**Tomingley Gold Project (09_0155)
Exhibition of Environmental Assessment**

I refer to your letter dated 8 November 2011 regarding the Alkane Resources Limited proposal to develop the Tomingley Gold Project. NSW Trade & Investment, Regional Infrastructure & Services (DTIRIS), Division of Resources & Energy (DRE) has reviewed the *Tomingley Gold Project Environmental Assessment* dated November 2011 (EA) and provides the following comments which are directed at specific areas of DRE responsibility for this proposal:

Figure 8
MINE SITE LAYOUT

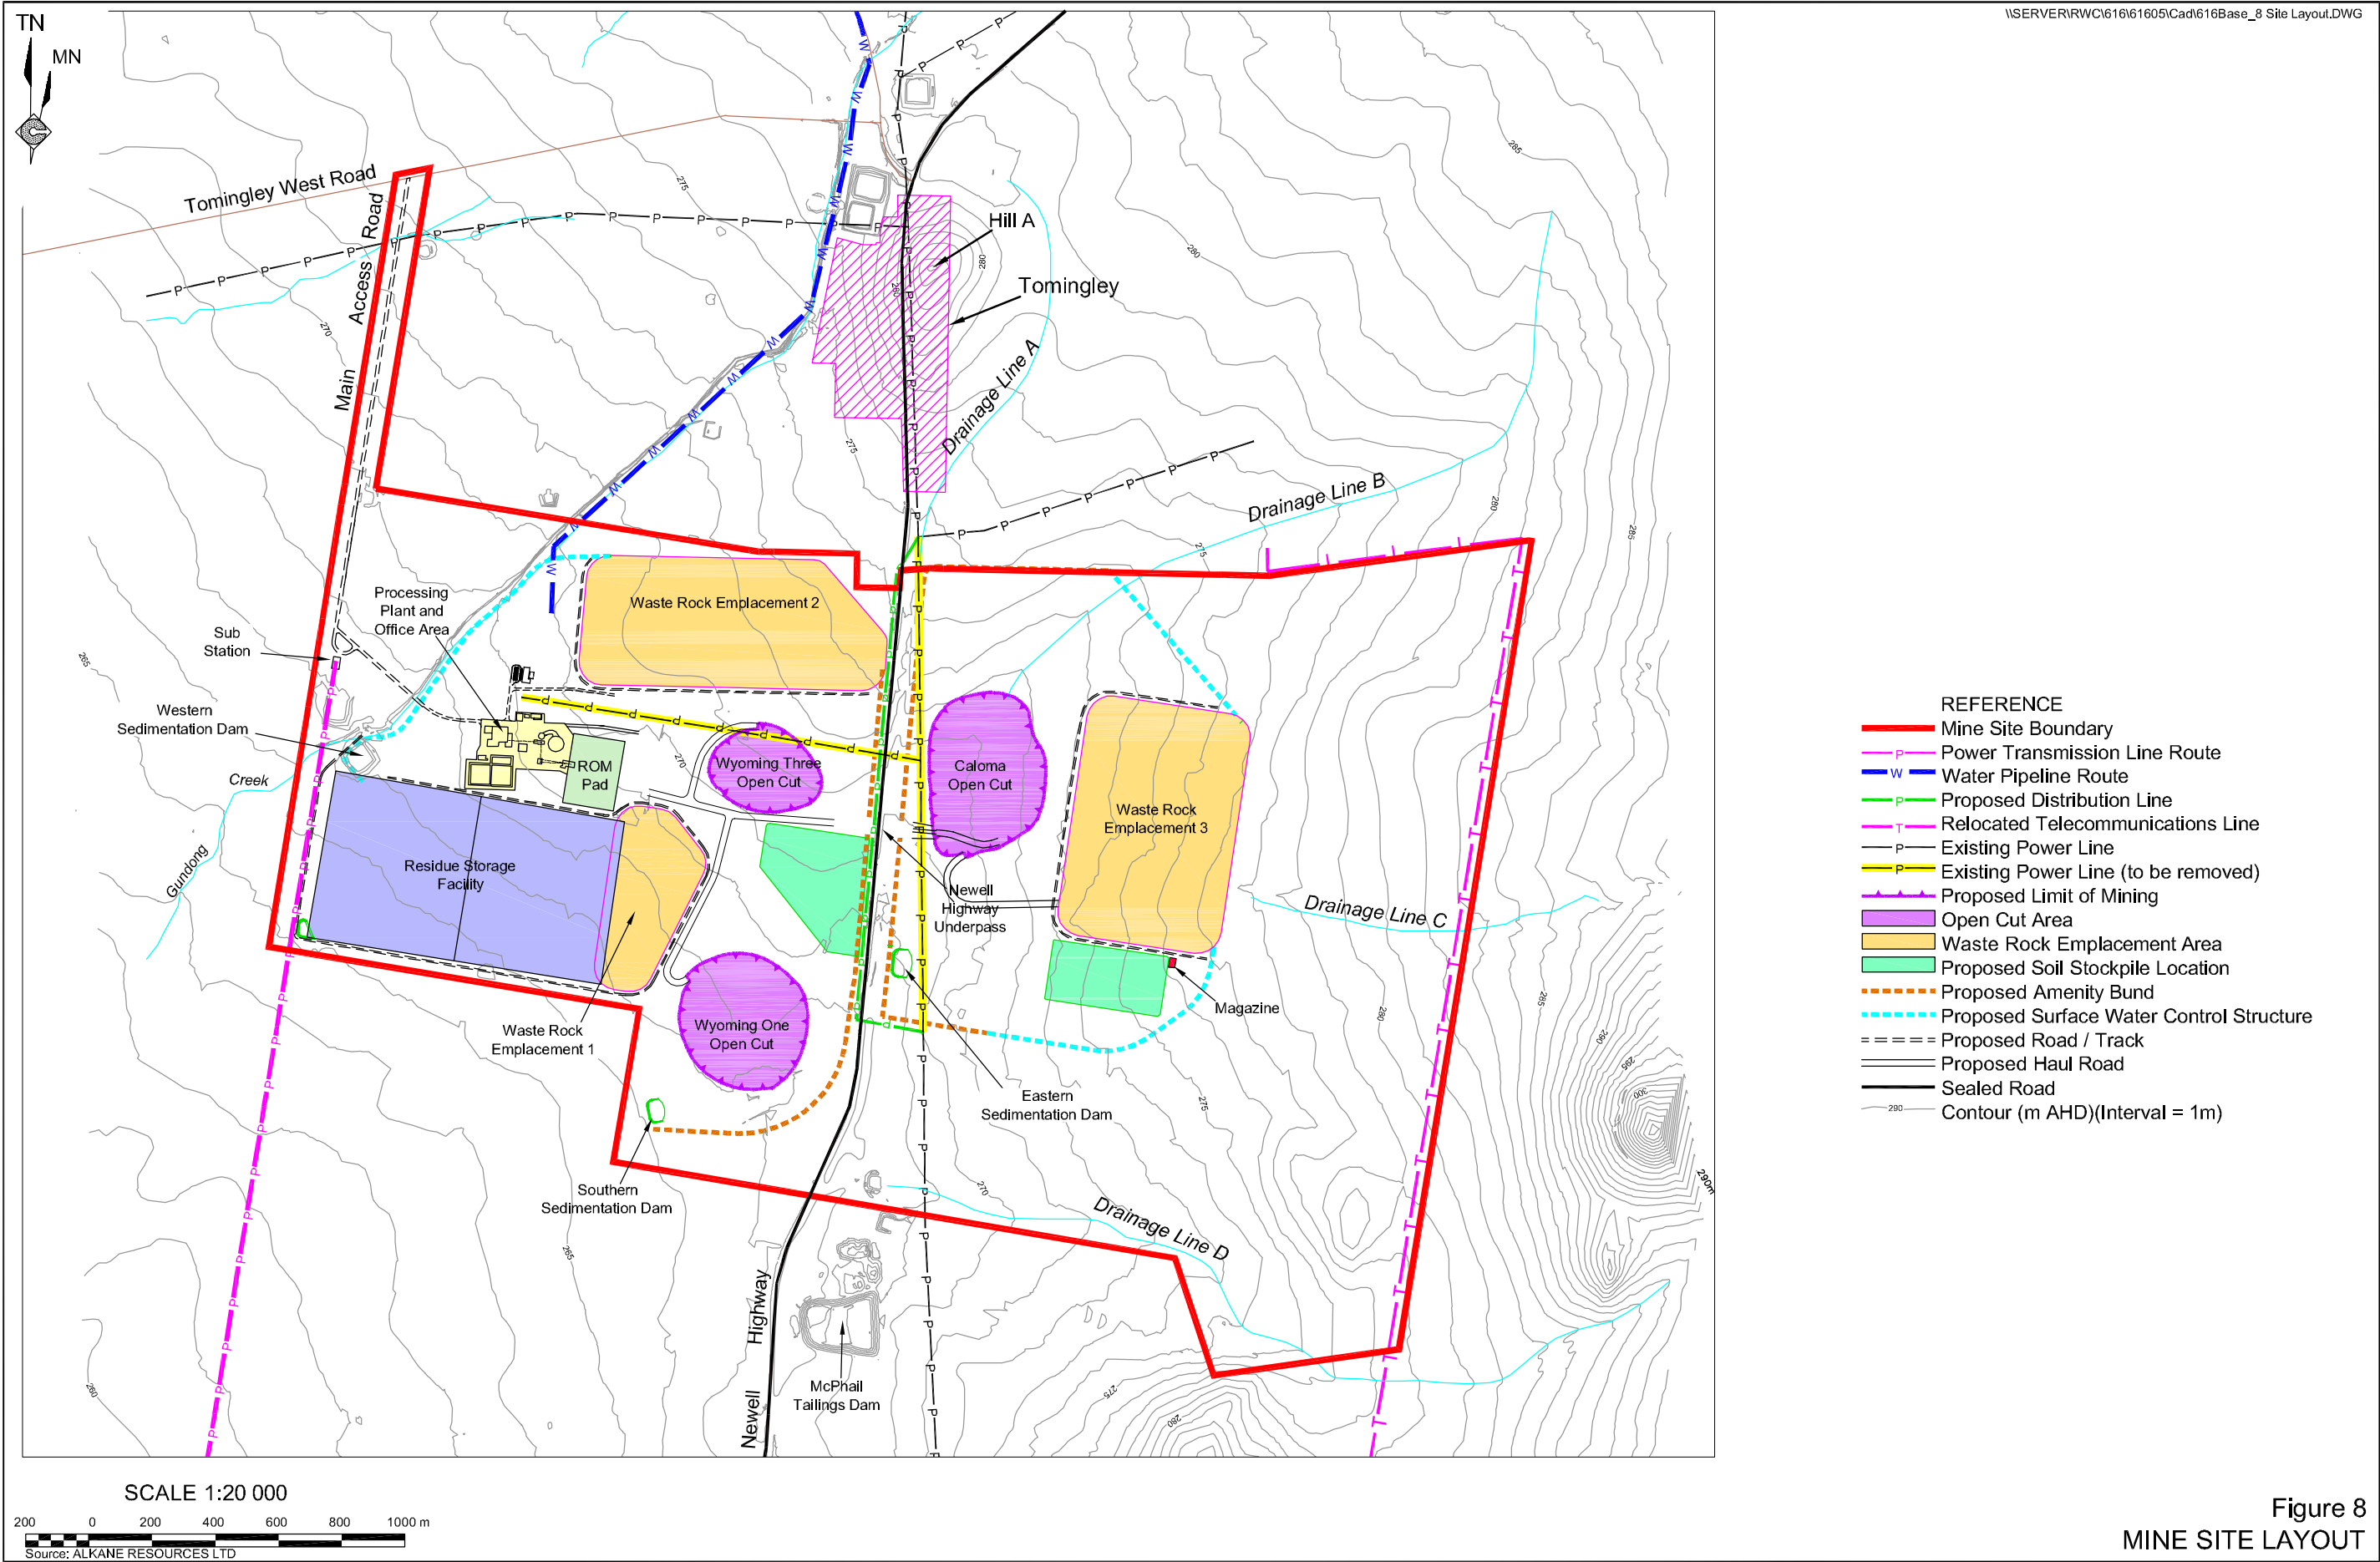
- Low grade ore/mineralised waste – there is no indication of where low grade ore and/or mineralised waste would be stored in the mine layout. Given that the rate of ore extraction rate varies over the life of the mine from a peak of 1.5 million tonnes to a few hundred thousand tonnes near the end of the mine life there is a need for the temporary storage of low grade ore/mineralised waste. If this material is to be sterilised by placing it onto the waste dumps then there is a significant resource utilisation issue that needs to be addressed.

The issue of pit stability was raised with regard to the Caloma Pit and the Newell Highway in the DRE submission to the Director General Requirements (DGRs). That issue and the related matter of the location of Waste Rock Emplacement 3 possibly within the zone of instability of the Wyoming Three open cut, **has not been addressed in the EA** or recognised as a risk in the EA risk analysis.

- More information regarding in-situ resources to provide justification for not back filling Caloma, Caloma 2 and Wyoming 2 voids.
- The location of Waste Rock Emplacement 3 possibly within the zone of instability of the Wyoming Three O/C, as a risk in the EA risk analysis.
- An active revegetation strategy will need to be adopted to achieve the stated land use goal.
